10-06-2013

RE OLD VICARAGE COTTAGE
PLANNING APPLICATION LY/10/13

MISS S POLLOCK
OLD VICARAGE COTTAGE
LYMINSTER
FENCE ELEVATIONS
SCALE 1-200

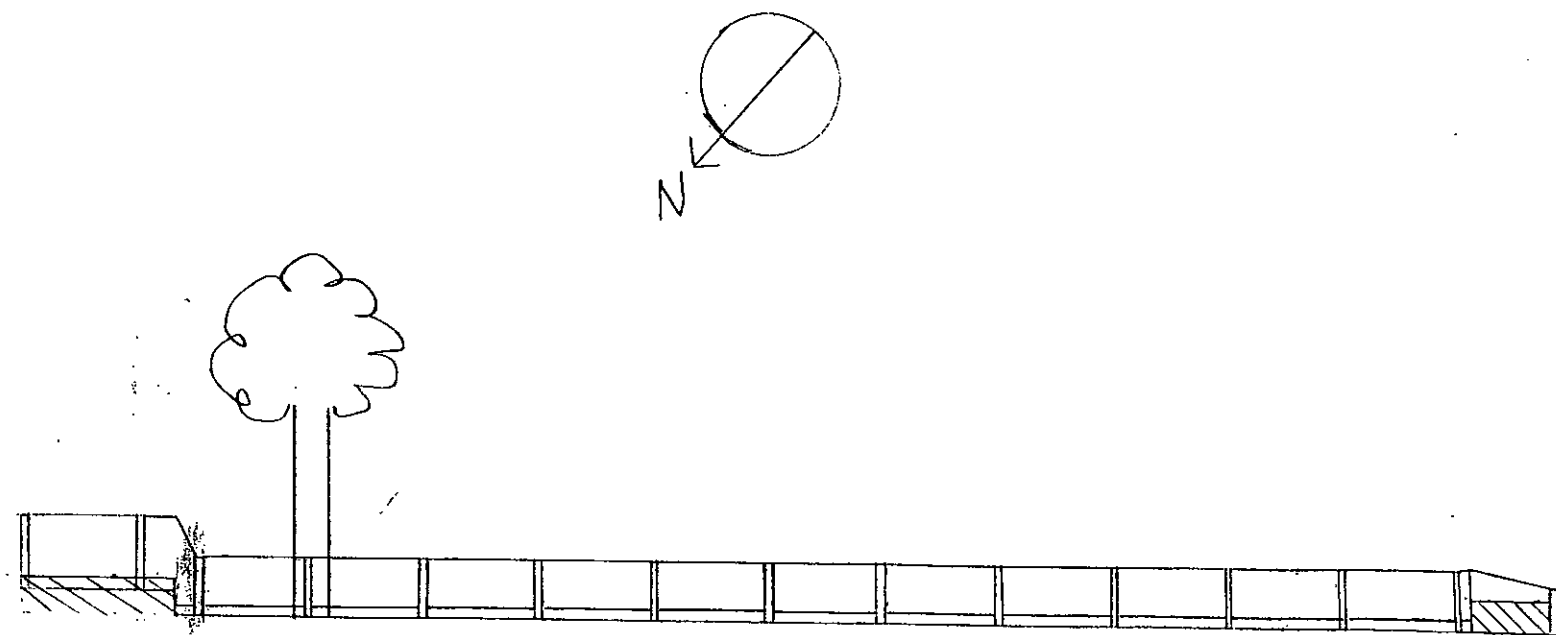
- 1/ IT IS AN UGLY APPENDAGE TO A VERY ATTRACTIVE
OLD COTTAGE & TOTALLY OUT OF CHARACTER
WITH BOUNDARY TREATMENT OF ADJACENT
& SURROUNDING PROPERTY
- 2/ IT IS ERECTED OUTSIDE OF AND CONCERNS AN
ATTRACTIVE LOW BOULDER BOUNDARY WALL AND
AT 1.8 METRES HIGH IS WELL ABOVE THE
ONE METRE HIGH LIMIT PERMITTED
- 3/ AS IT IS ERECTED ON THE ROADSIDE VERGE,
IT IS PROBABLY ON LAND OWNED BY THE
HIGHWAY AUTHORITY
